Our ref: HMS ID 10223

Advice on Environmental Impact Statement – State Significant Development

Proposal: Mixed use development with infill affordable housing

Major Project reference: SSD-77260958

Figure 9. 1890 sale plan for the estate of the late Mrs. Halloran, showing the two structures at the rear of Lot 1 (within the Project Area), Michael O'Keefe's house to the south, and a pencilled notation of 'O'Keefe' on Lot 3. (Source: SLNSW Z/SP/811.1834, SP/811.1834)

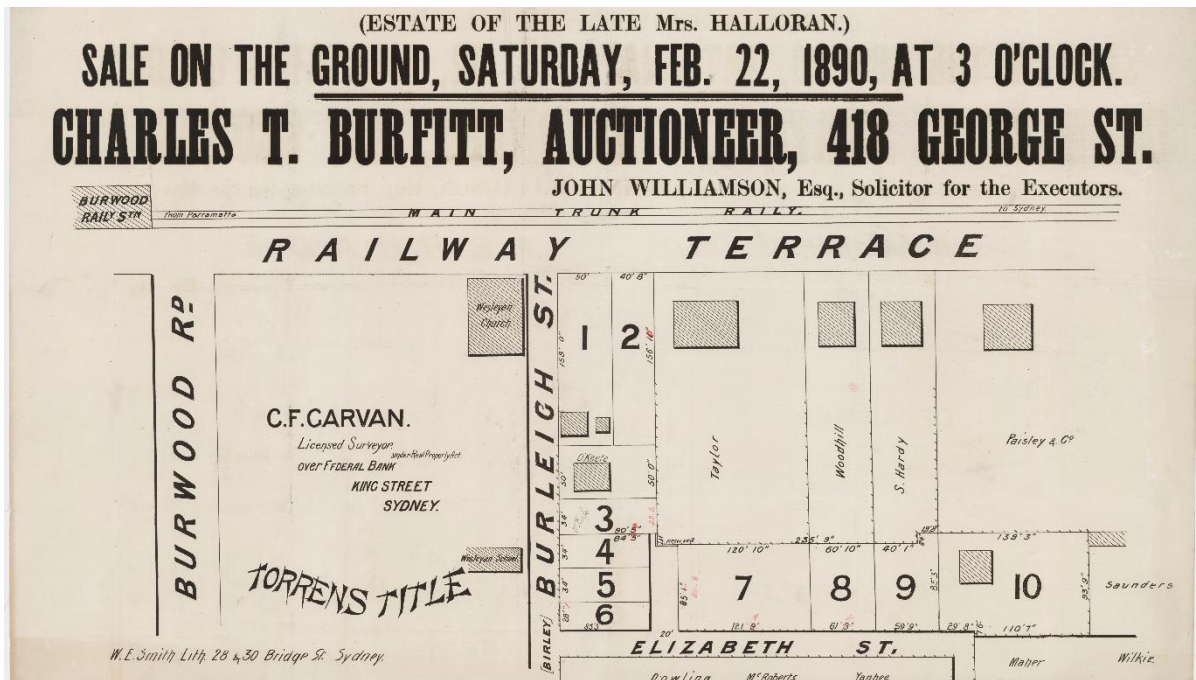
1. Heritage NSW note that the 1890 Subdivision Plan (Figure 18 in the HIS) shows two unidentified buildings in the rear of the block that predate the widespread residential development of Burwood. Please provide further detail regarding these structures, namely:
 - a. Their history or likely dates of construction
 - b. The potential use of the site pre-1890
 - c. The potential for ancillary buildings associated with the main structures
